MDT-PUDSP22001-R1-PUD.pdf Markup Summary

SHEET 01 OF 25
PUDSP 22 1

**SITE PLAN**  
**SP07**  
SHEET 11 OF 28  
PCD FILE NO.: PUDSP221

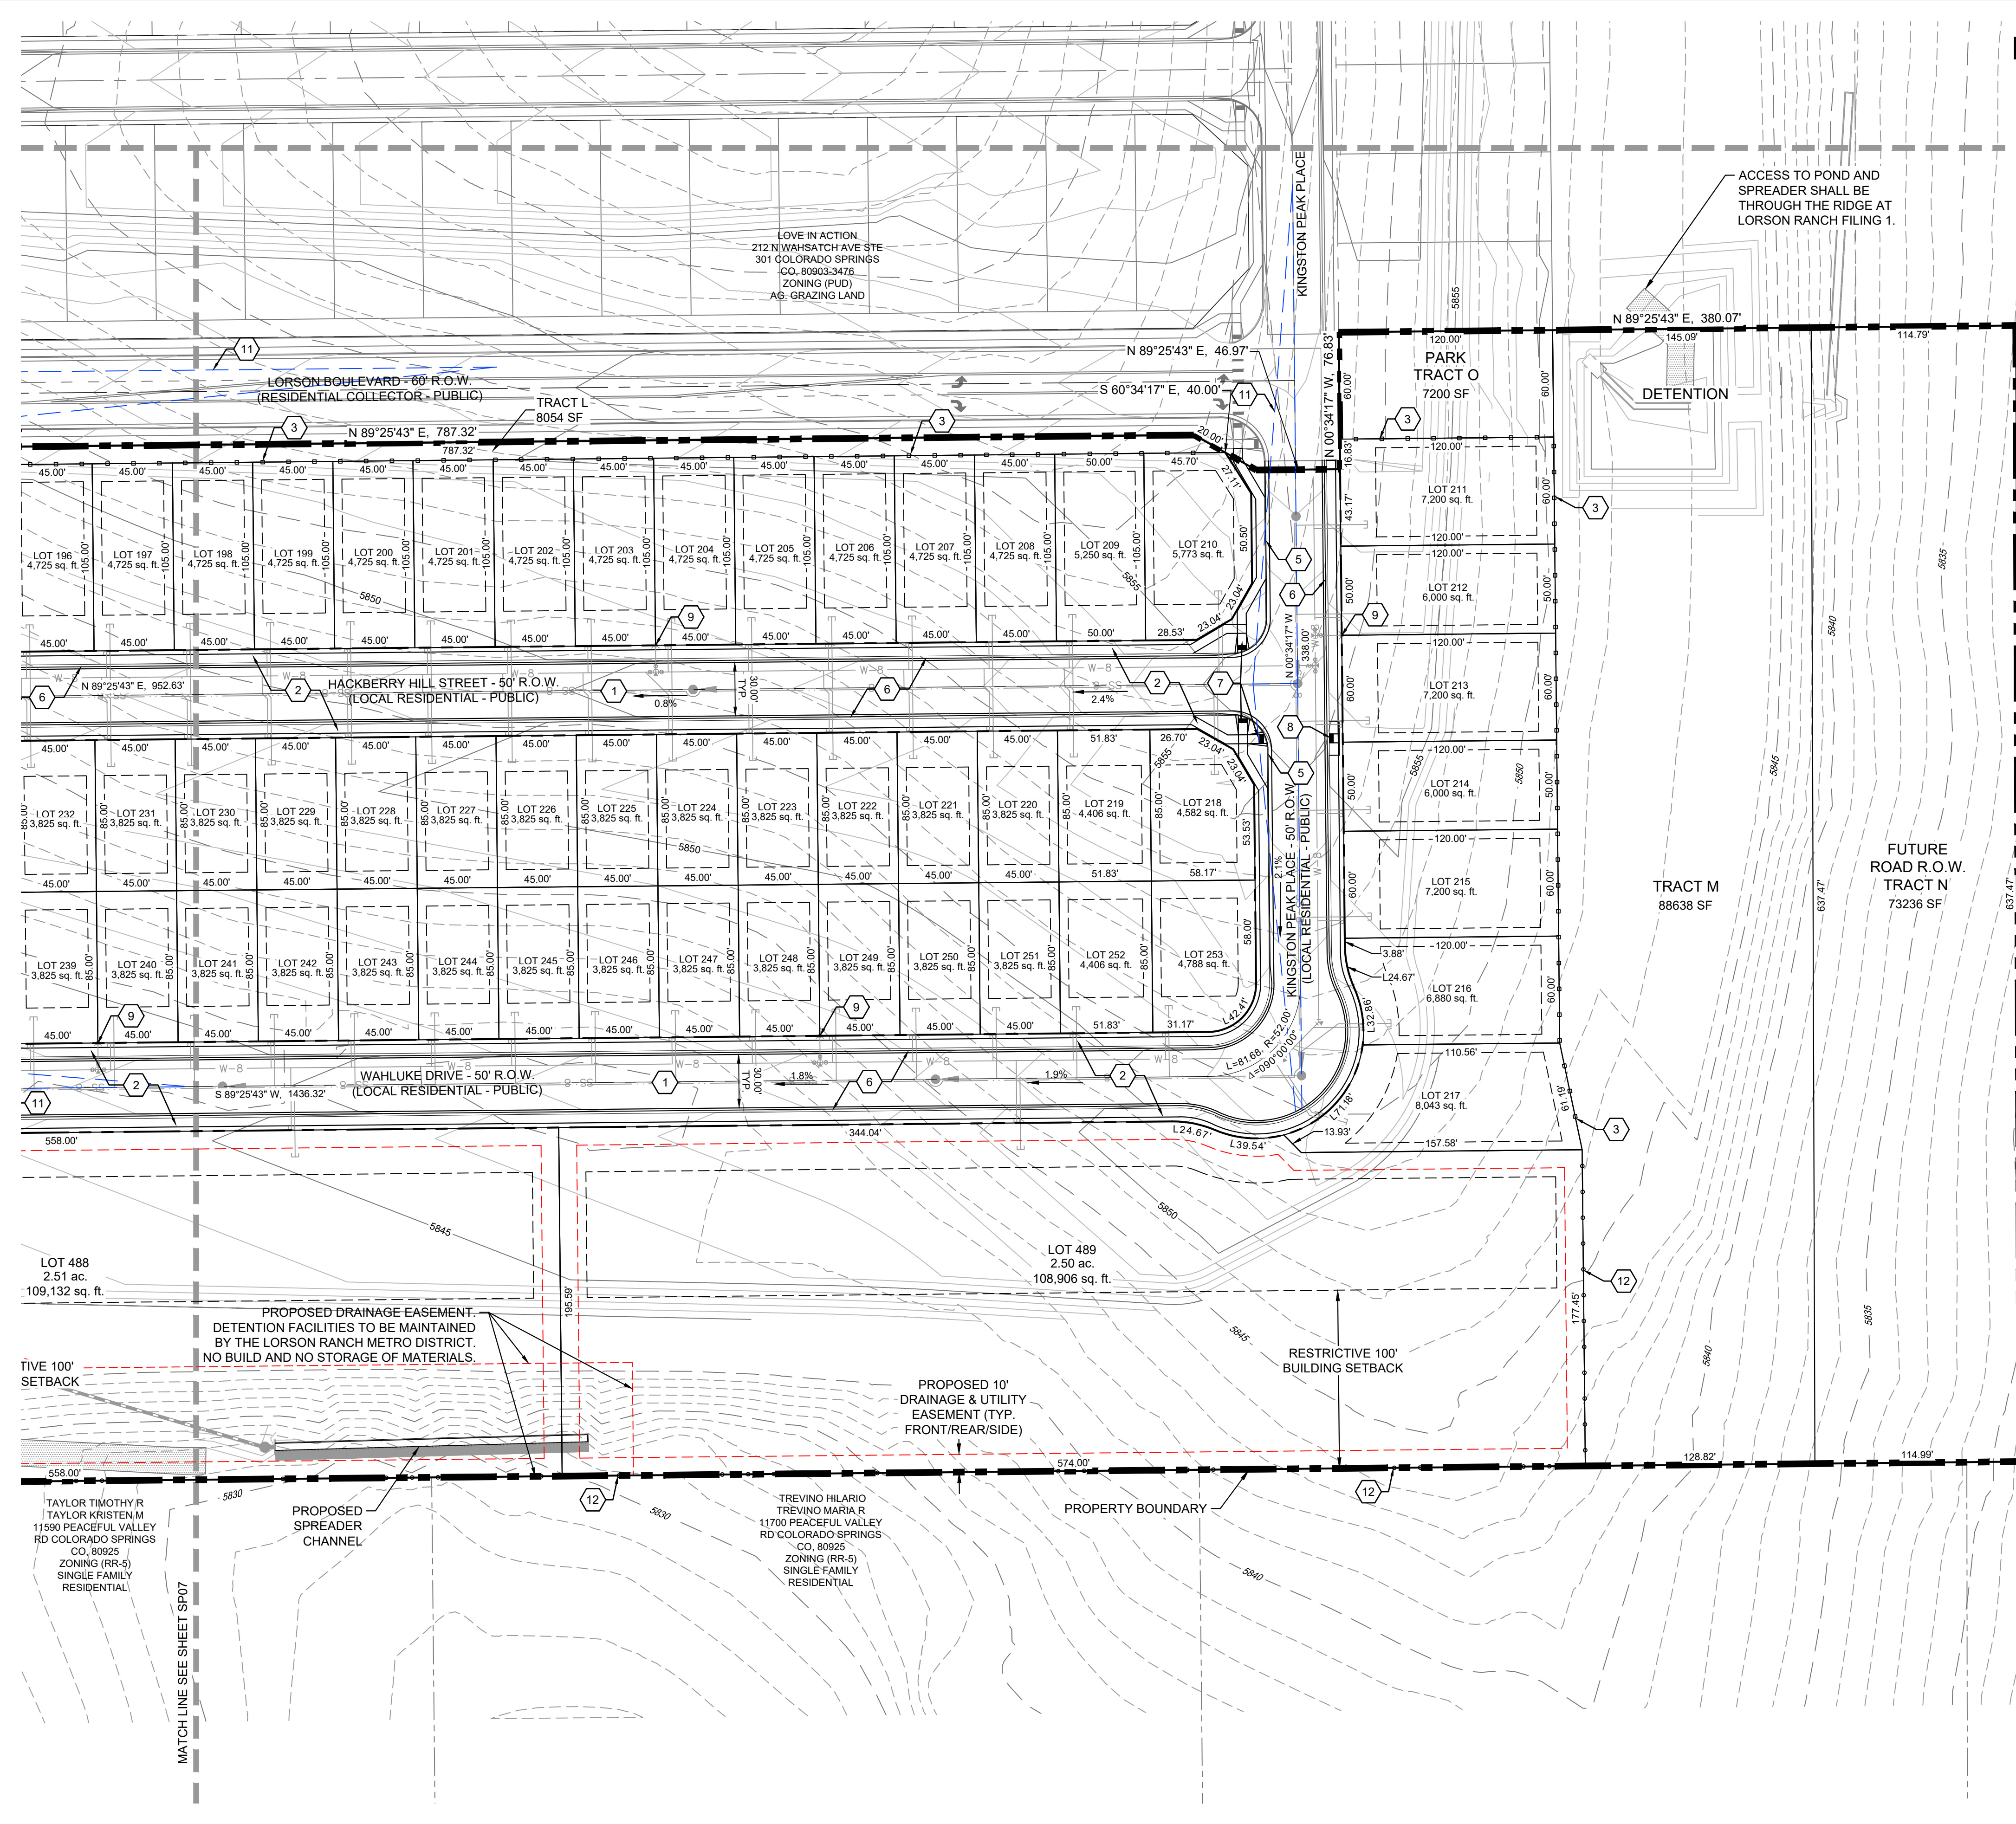
these lots should identify the side, rear, front utility and r drainage easements as req perCode. Typical are for the urban lots not the rural

these lots should identify the side, rear, front utility and r drainage easements as req perCode. Typical are for the urban lots not the rural
